# **GATWICK AIRPORT NORTHERN RUNWAY PROJECT**

Planning Inspectorate's Reference: TR020005

### **Comments on The Applicant's Response To The ExA's Written Questions (ExQ1)**

### **Response to [\[REP3-089\]](#) | Development Consent Order and Control Documents**

Permanent Diversion of 346_2Sy

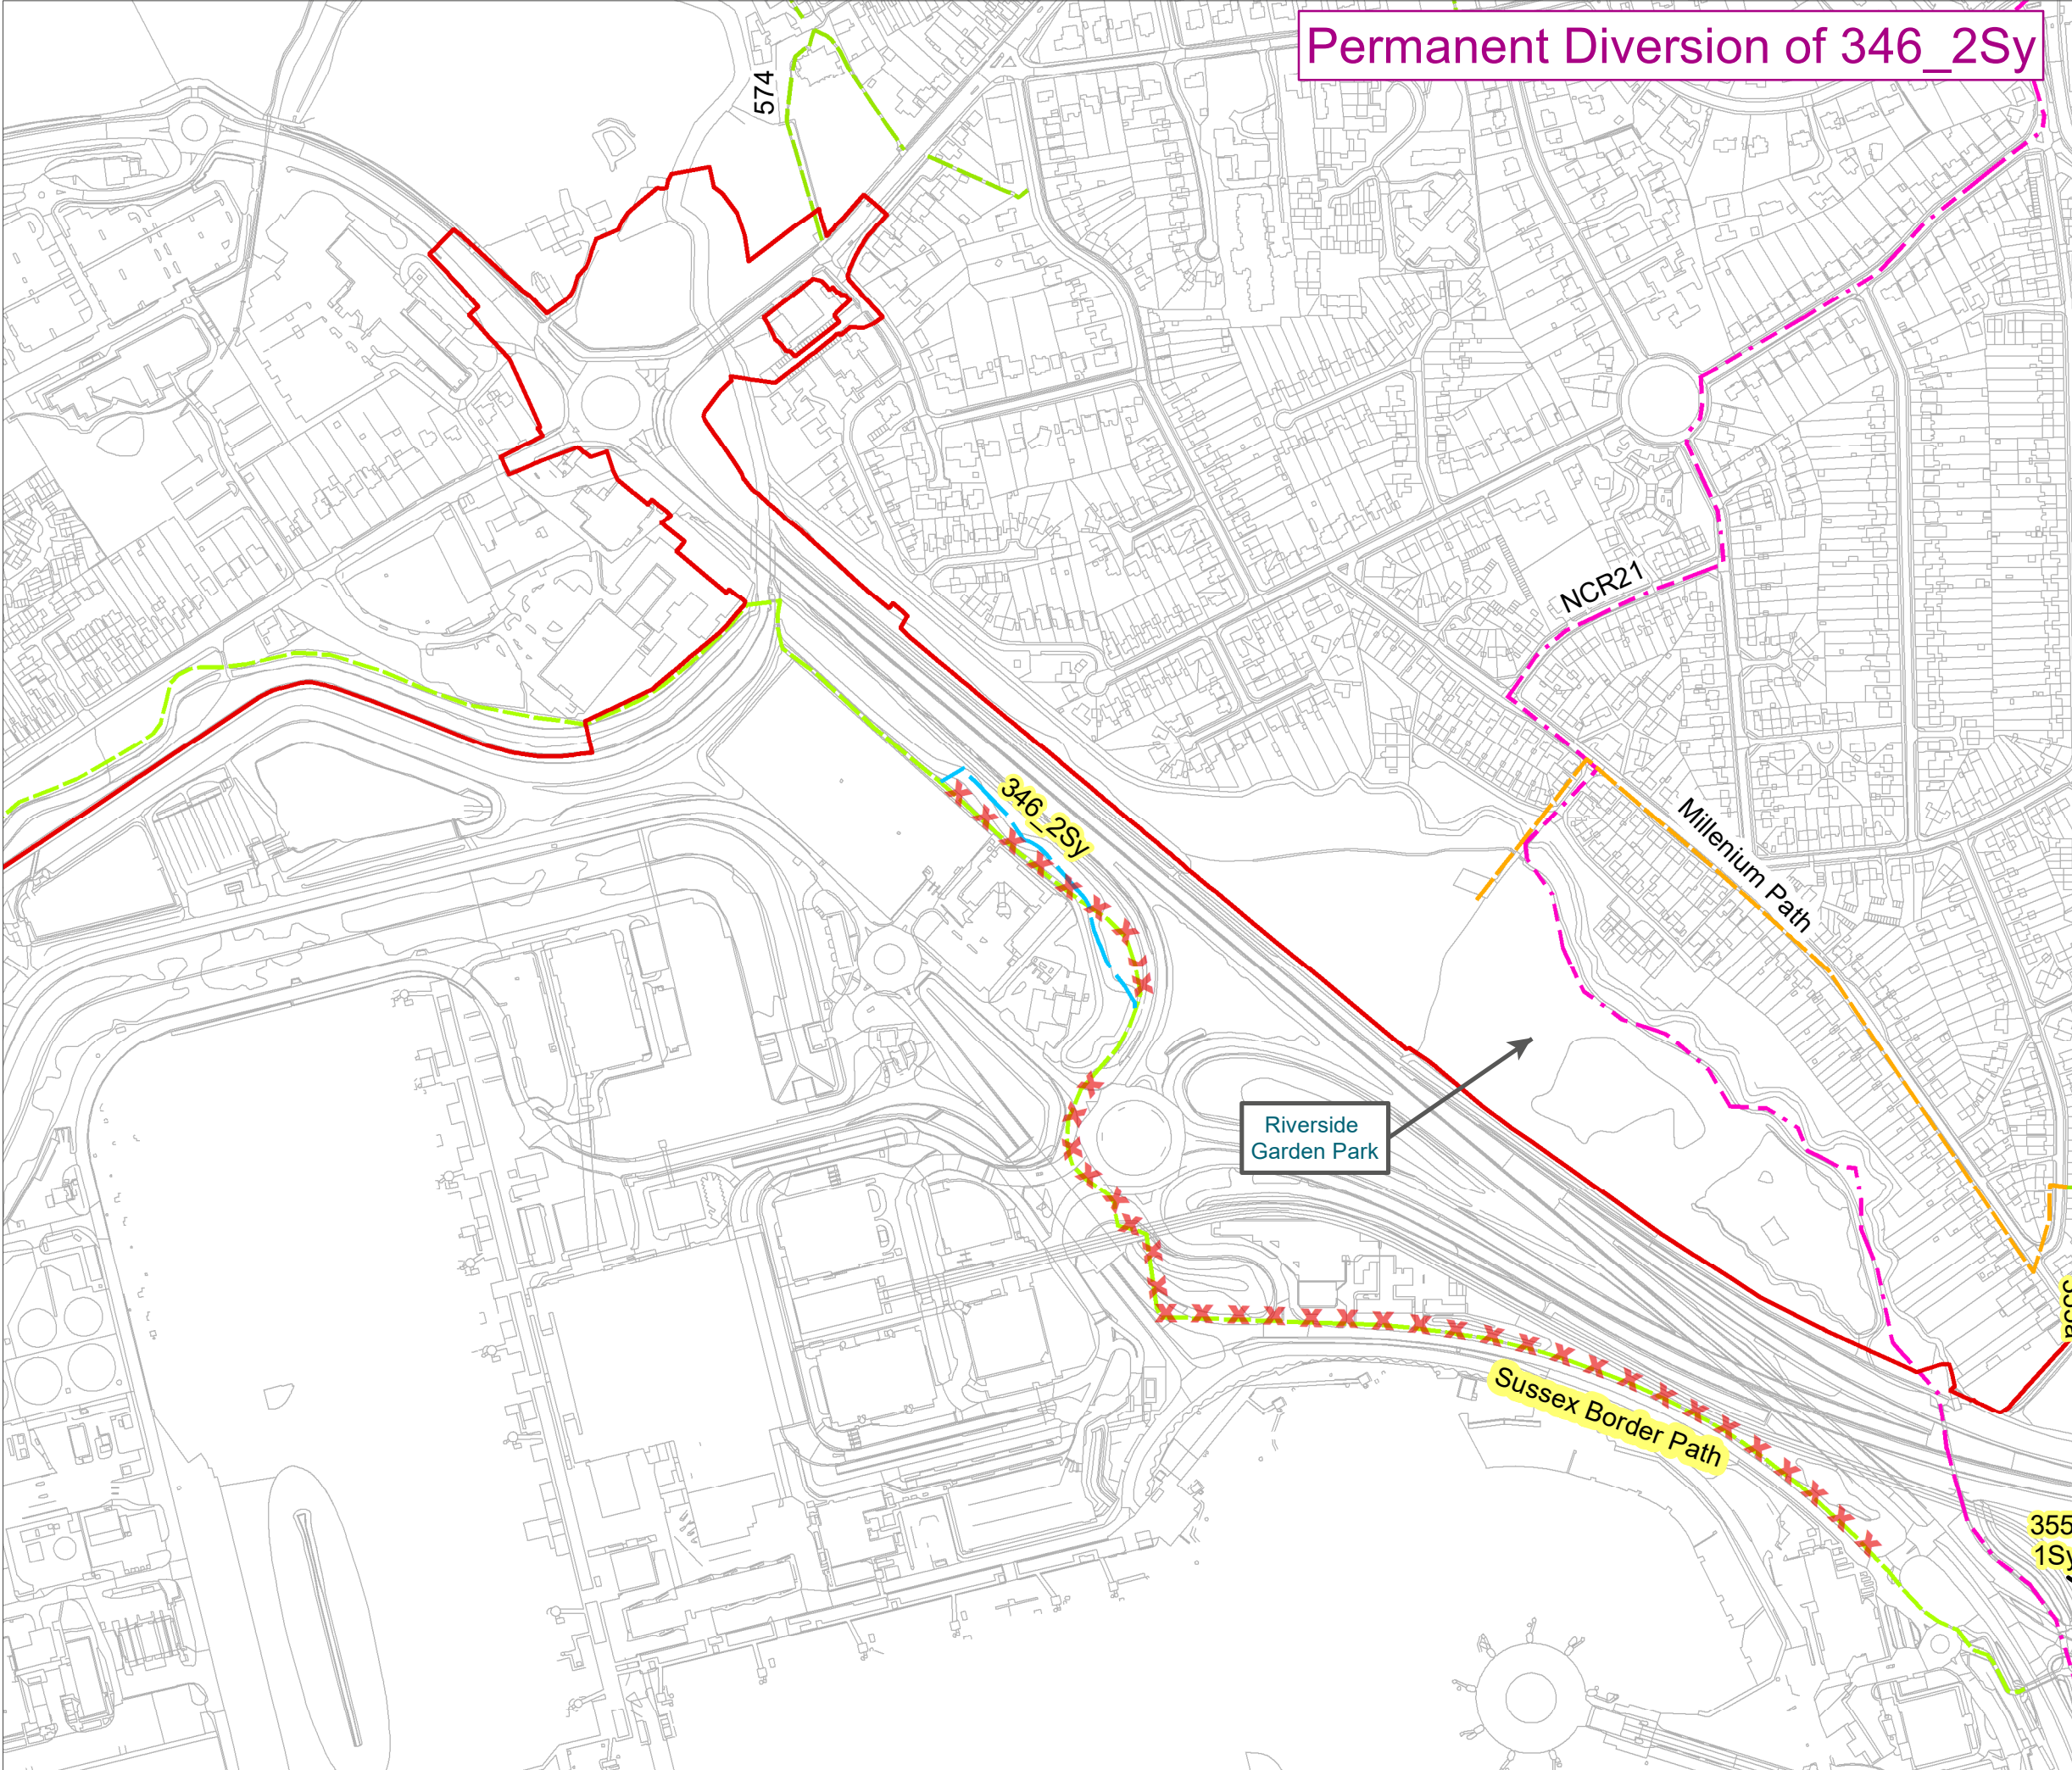
<p>is no substitute provided?</p> <p>The relevant section of Footpath 346_2sy is labelled as Reference B2 on Sheet 1 of the <b>Rights of Way and Access Plans</b> [REP1-014]. Whilst no substitute public right of way is to be provided, alternative substitute footway and shared-use cycle track provision is proposed that reflects a rationalised version of the current footpath route as stated in Table 4.1.1 of <b>ES Appendix 19.8.1: Public Rights of Way Management Strategy</b> [REP2-009]. The relevant labelled sections of the replacement route on Sheet 1 of the Rights of Way and Access Plans are as follows: c11 (southwestern section), c8 (eastern section), c40, c6, c5, c4, c3 and c2. These new tracks are listed separately in Part 3 (footways and cycle tracks) of Schedule 4 to the <b>dDCO</b> (Doc Ref. 2.1 v6).</p> <p>This approach has been adopted for this section of footpath as it is currently coincident with various rights of way with a highway designation (including Longbridge Way, North Terminal Roundabout, Gatwick Way and Perimeter Road North and the associated footways which form part of the highway). To address this existing issue of overlapping rights of way the footpath is to be stopped up where it is coincident with highways (as is the case elsewhere along the footpaths associated with Sussex Border Path) and substituted by the alternative footway and shared-use cycle</p>	<p>side road entry which offers priority to pedestrians and cyclists.</p>
